Re: AW/246/19/PL – Erection of 1 No. 2 Storey End of Terrace House at land adjacent to 34 Wakefield Way, Bognor Regis PO21 3RS

Reference: - AW/246/19/PL ~ Erection of 1 No. 2 Storey End of Terrace House

OBJECTION TO THE AFOREMENTIONED APPLICATION

PROJECT	Wakefield Way	DATE	19/08/19
TITLE	Site Plans	DRG NO	IBA/520/01
SCALE	As Noted	REVISIONS

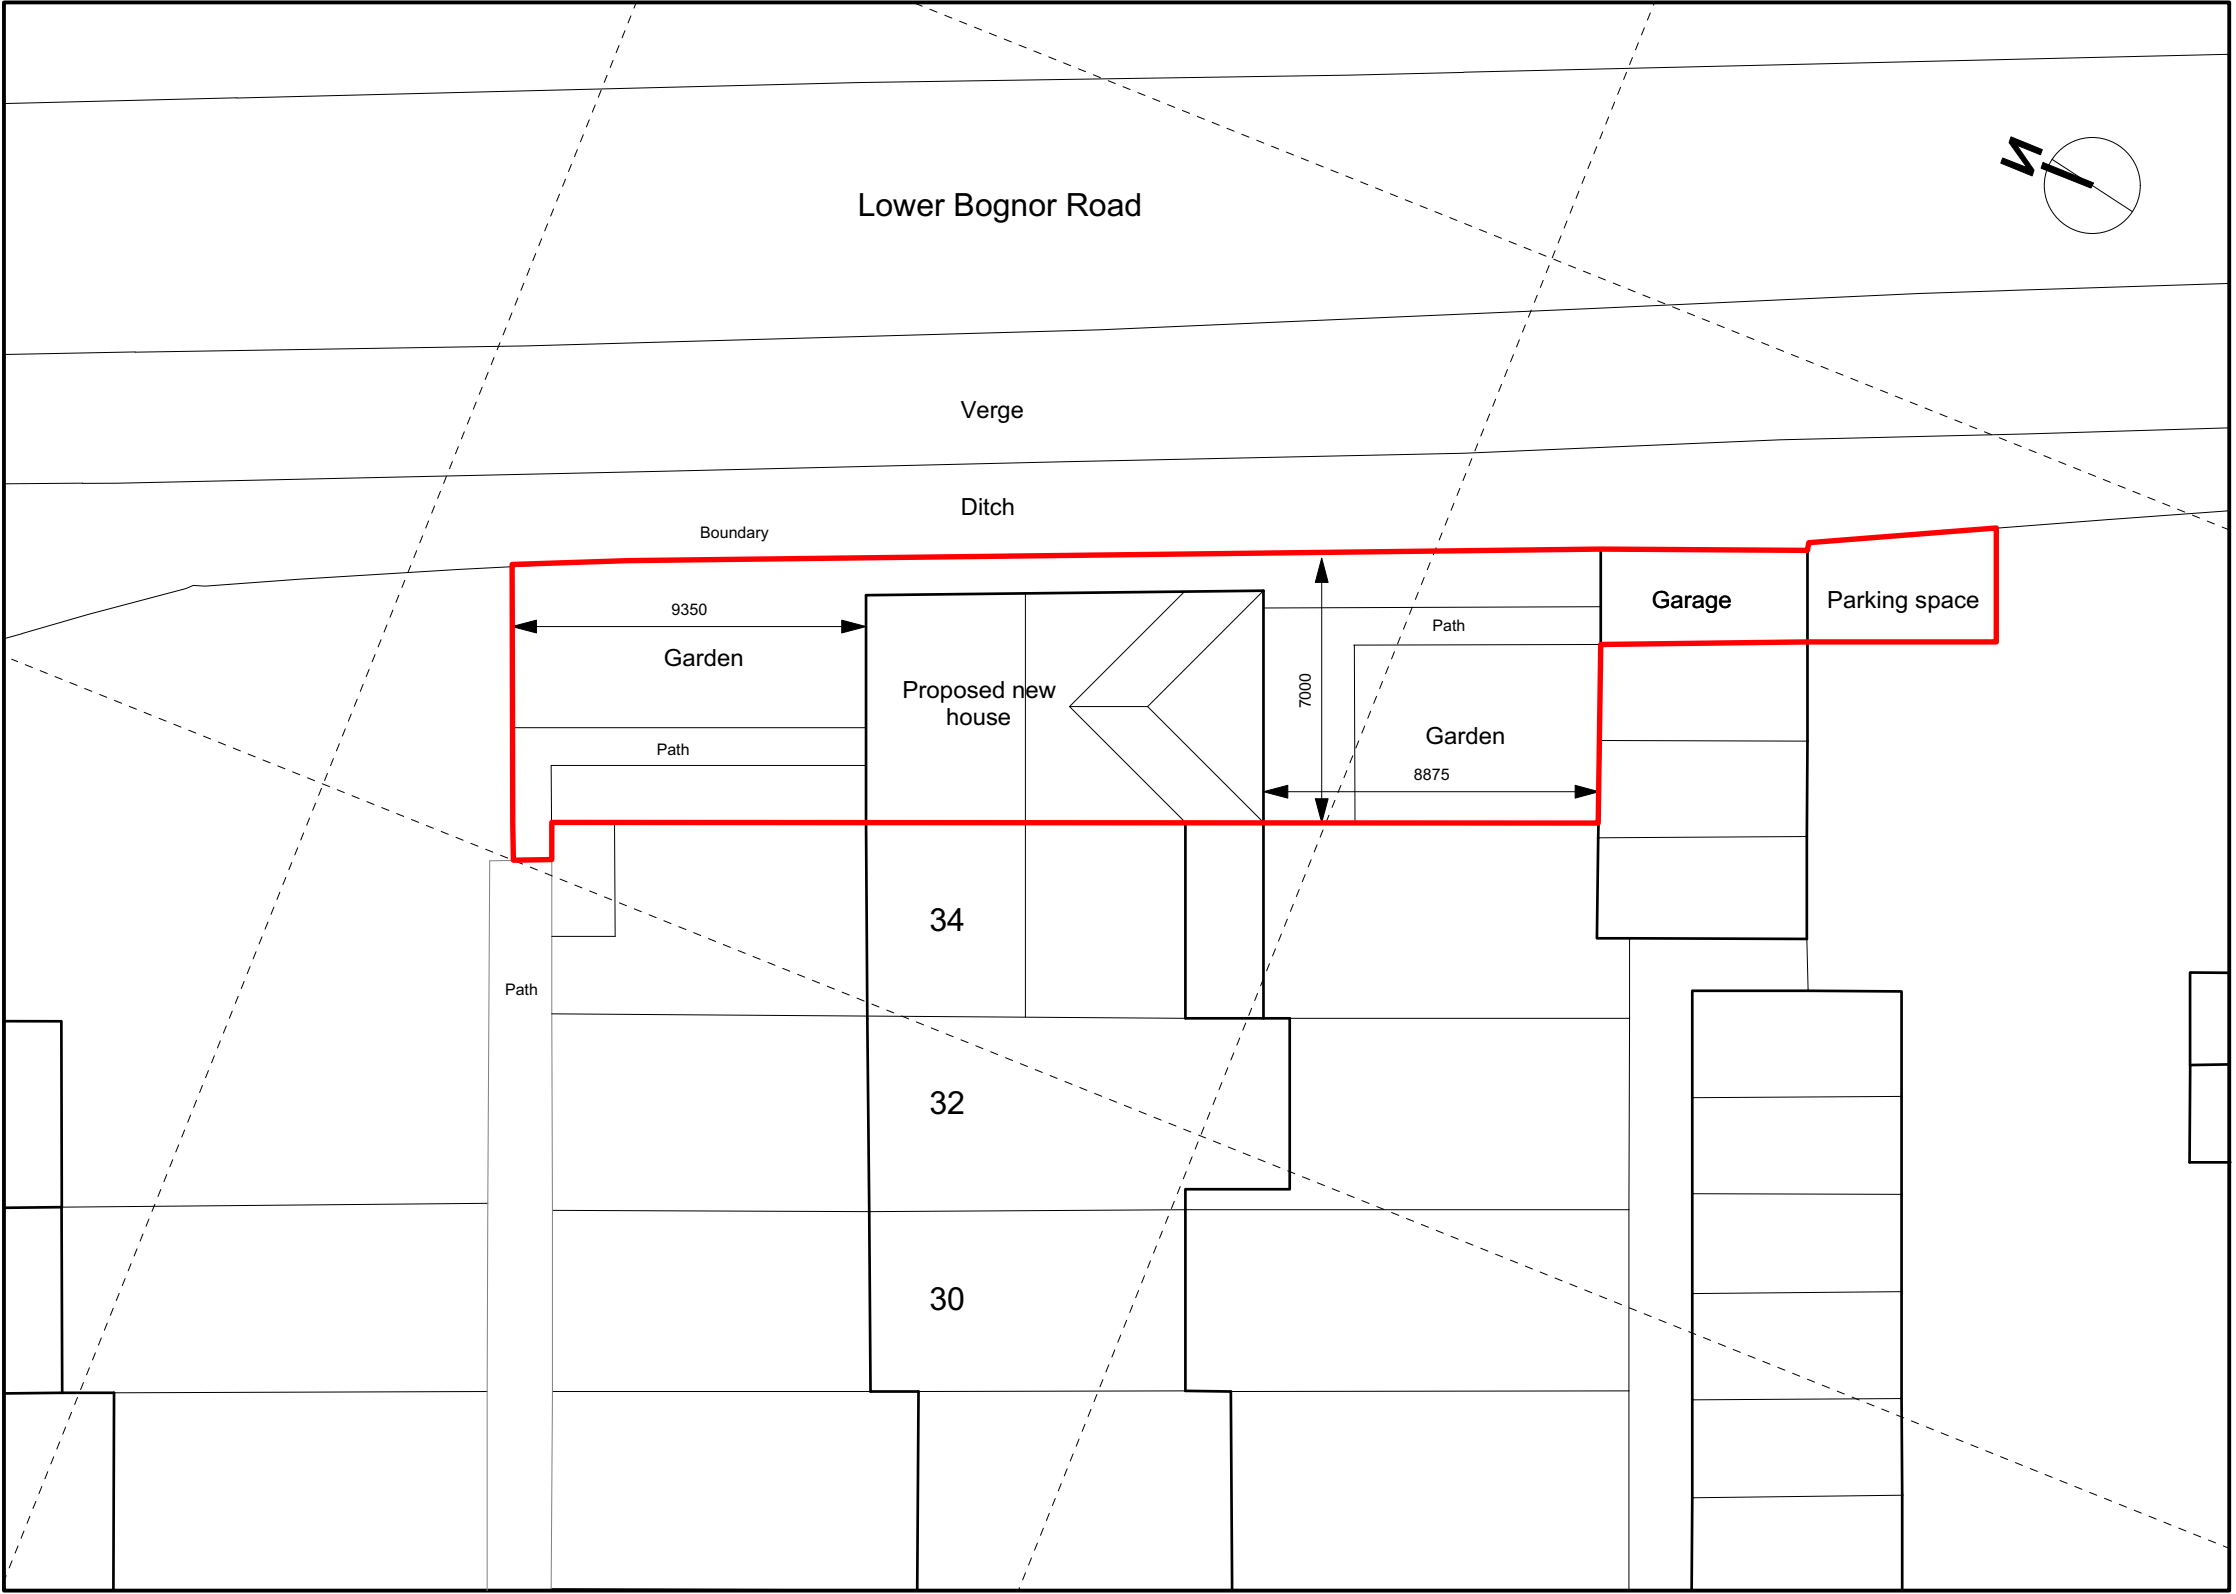
I refer specifically to IBA Drawings IBA/520/01, 02 & 03.

In paragraph 2 of the Design and Access Statement on Page 5 of the self-named document, I quote *"Parking is provided on site, with one garage space and one parking space in front of the garage"*

According to the WSCC Consultation on the planning application the WSCC PDC **requires** a minimum of three parking spaces to be provided for this size dwelling in this location.

According to the D&A Statement the proposal by the Applicant would only give 2.

It is our belief that neither of these two proposed spaces constitute a parking provision for the dwelling.

The first of which is a garage situated at the far end of the L/H side of the garage block. This garage is apportioned to No.34 (the existing dwelling) therefore no "additional" space has been created, it has simply been re-assigned from an existing dwelling to the proposed. This conclusion has also been noted within the WSCC Consultation.

There is also a further point to the proposed use of a garage as a parking space within this application. As per the WSCC Consultation, the garage in question is only 2.5m wide and 5.5m long. This is barely big enough for a standard size family vehicle. However, the Design and Access Statement submitted makes note that the garage will also be the "Bin Store" for three wheeled refuse bins along with space for two bicycles. I do not see how a car, three wheelie bins and two bicycles will fit into this garage. The floor space is simply not enough.

Secondly the area of hard standing in front of the garage cannot be assigned to any one property as it does not fall within the ownership boundaries of the existing dwelling.

Therefore, no portion of the forecourt area can be apportioned to any one property as its title belongs to all persons entitled under the same Schedule accompanying their deeds.

In short, no provision of any spaces has been provided for the new dwelling, therefore not meeting the regulatory 3 spaces as set down by the WSCC in their PDC.
